**KIRKLEES METROPOLITAN COUNCIL  
INVESTMENT & REGENERATION SERVICE**

Reference No:	<b>2023/62/90172/W</b>
Site Address:	114, Fitzwilliam Street, Huddersfield, HD1 5PH
Description:	Change of use, alterations, part demolition of boundary wall and erection of two storey side extension to convert from hot food takeaway to residential (Listed Building within a Conservation Area)
Recommending Officer:	William Simcock

## **Officer Report 2023/90172**

### **114 Fitzwilliam Street, Huddersfield**

Drawing
Existing Elevations

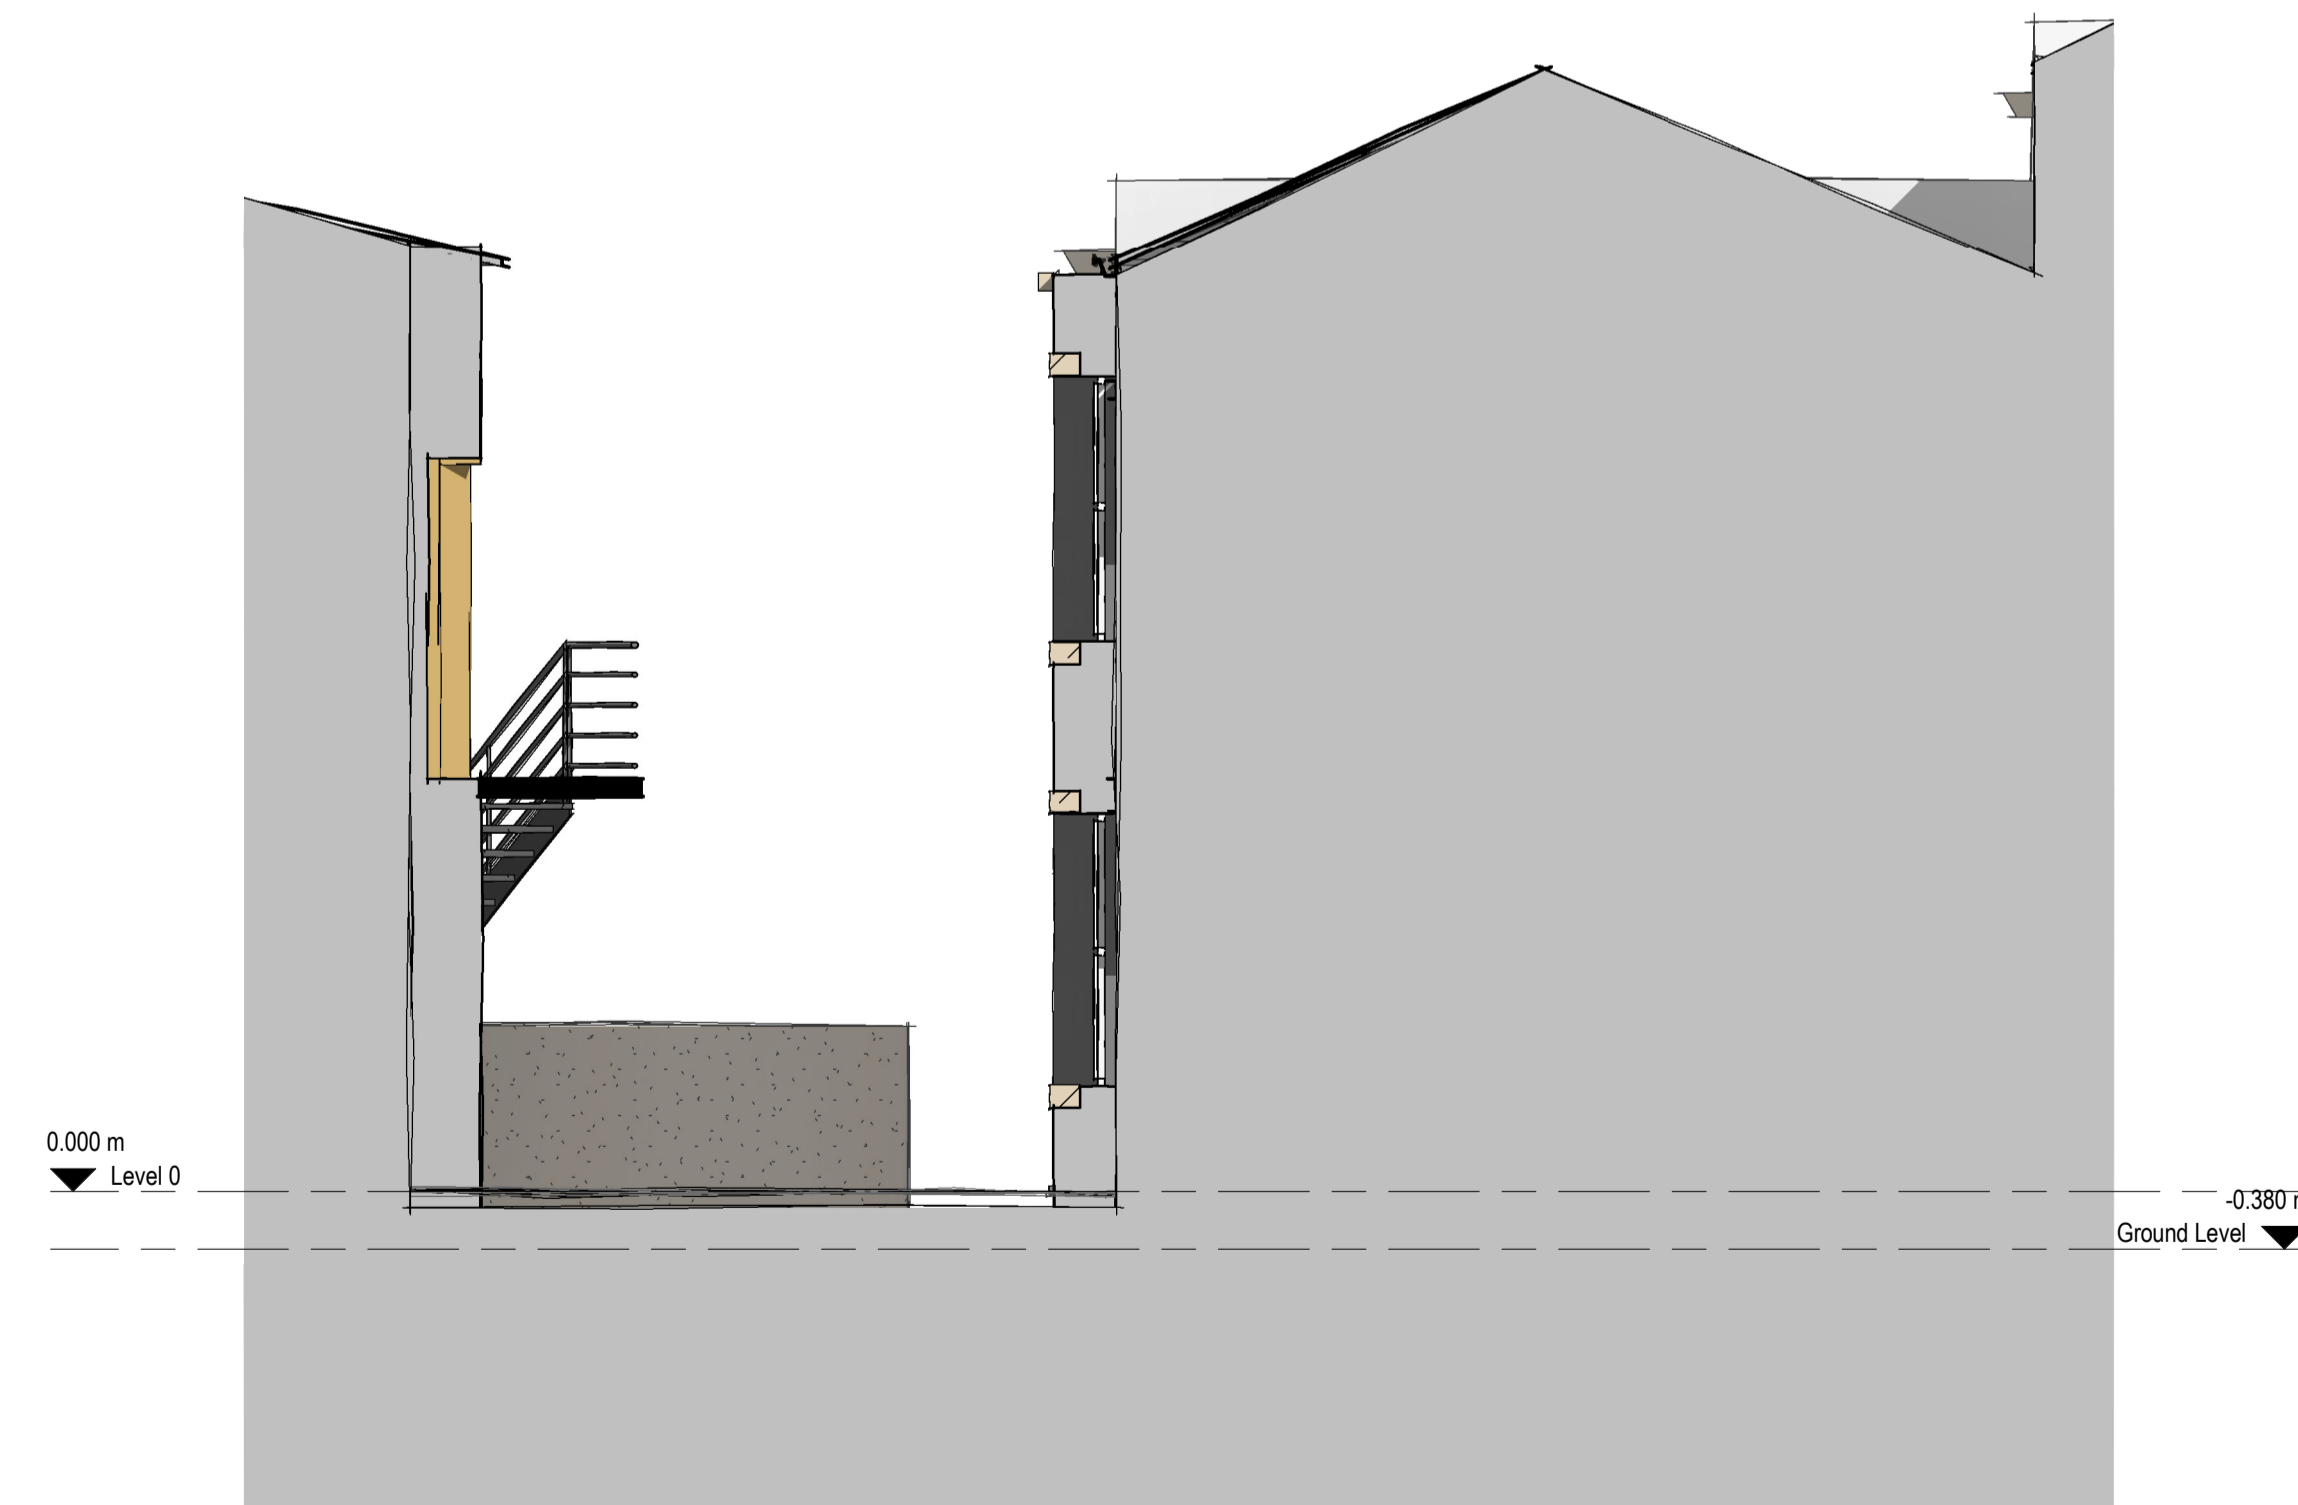
The principal elevation is finished in the finer ashlar stone whereas the side elevation is finished in hammer-dressed stone. The elevation does still have details of note, including original window and door openings and stone corbel gutter hangers. The elevation has always been exposed and prominent and there is no historic evidence to show that there has ever been any structure in this location.

1. The proposed development, owing to the scale, siting of the proposed extension, and by its resulting in the loss or obscuring of original architectural features in the side elevation and the substantial demolition of the boundary wall, would undermine the character and significance of the Listed Building, the setting of the neighbouring Listed Buildings, in particular no. 112 New North Road, and the character of the Greenhead Park / New North Road Conservation Area. The degree of harm caused is deemed less than substantial within the meaning of the National Planning Policy Framework (NPPF). It is considered that no public benefit has been demonstrated that would outweigh the harm caused in this instance. The proposals therefore do not accord with policies LP24(a) and LP35 of the Kirklees Local Plan, Chapter 16 (paragraphs 199, 202 or 206) of the NPPF, and would be incompatible with the Council's duties under the Planning (Listed Building and Conservation Areas) Act 1990.
